Rezoning Transportation Analysis

Petition Number: 2025-061

Date	Description
6-25-25	First Review (CM)

SHEET NUMBER
RZ-1

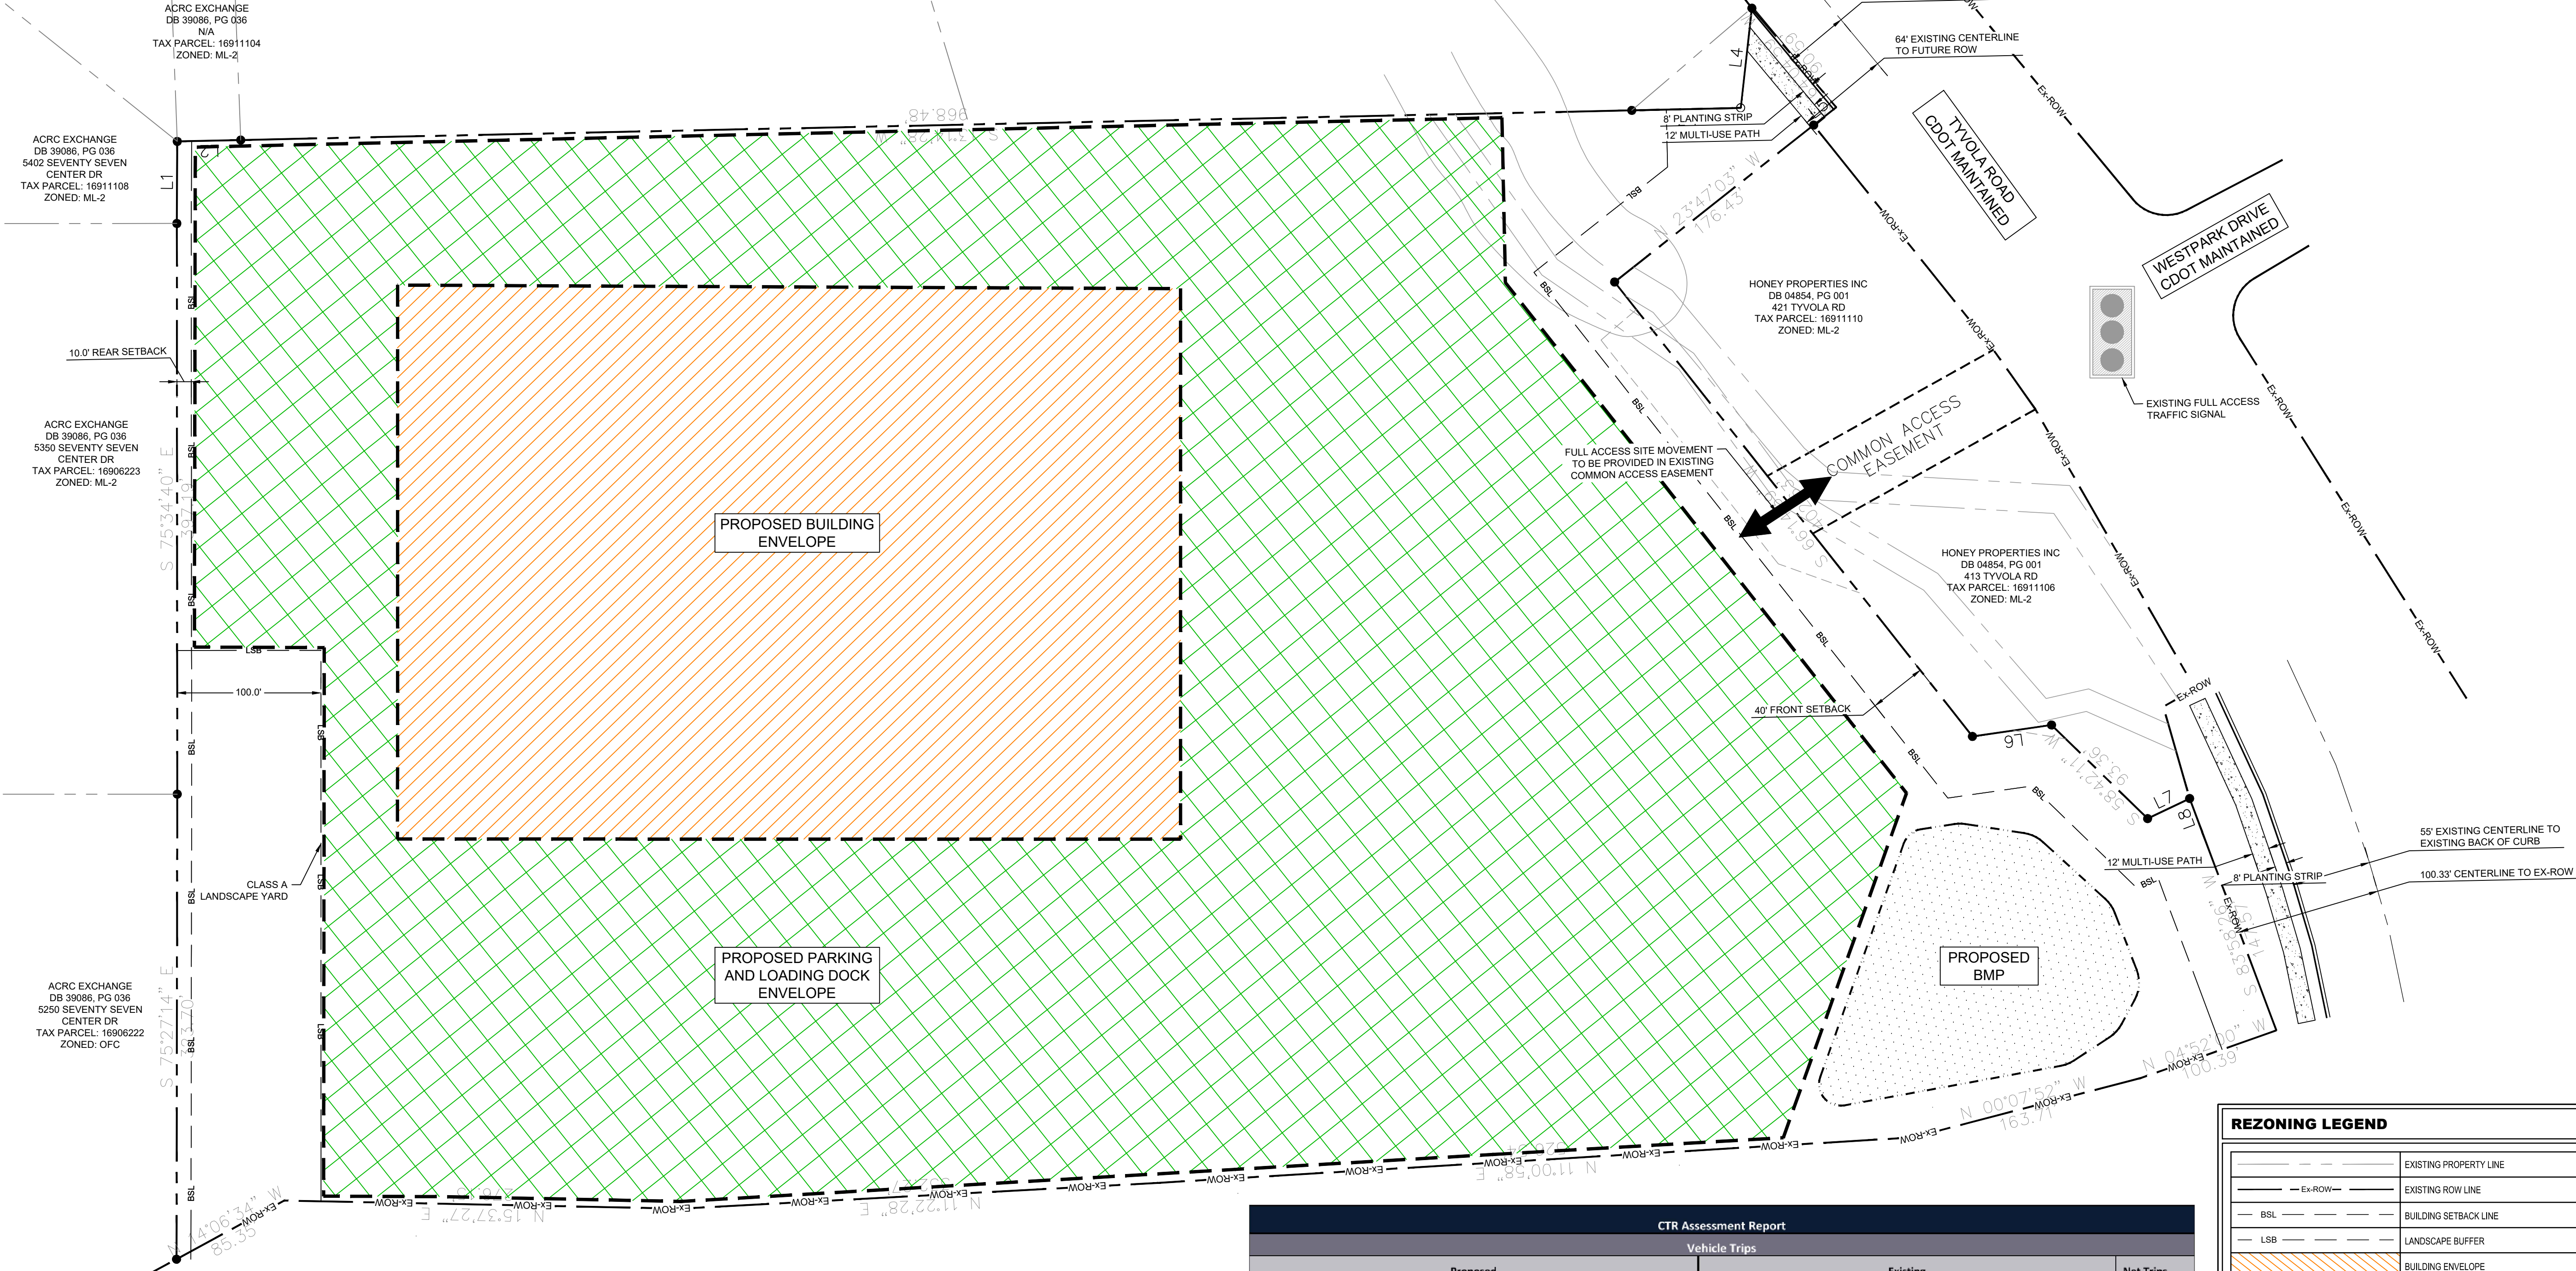
- Tyvola Road:** Location of future curb and gutter is 44' from the roadway centerline. The existing curb does not need to be relocated.

Label and dimension the curb and gutter from the centerline for each road on the site plan.

- Revise site plan and conditional note(s) to commit to dedicate 64' right-of-way from the road centerline. The site plan shall label and dimension the right-of-way from the road centerline.

4. Revise site plan and conditional note(s) to commit to construct bicycle facilities by installing a 12' multi-use path in accordance with the council-adopted Charlotte Streets Map. Multi-use paths maintained by the City shall meet ADA/PROWAG requirements.
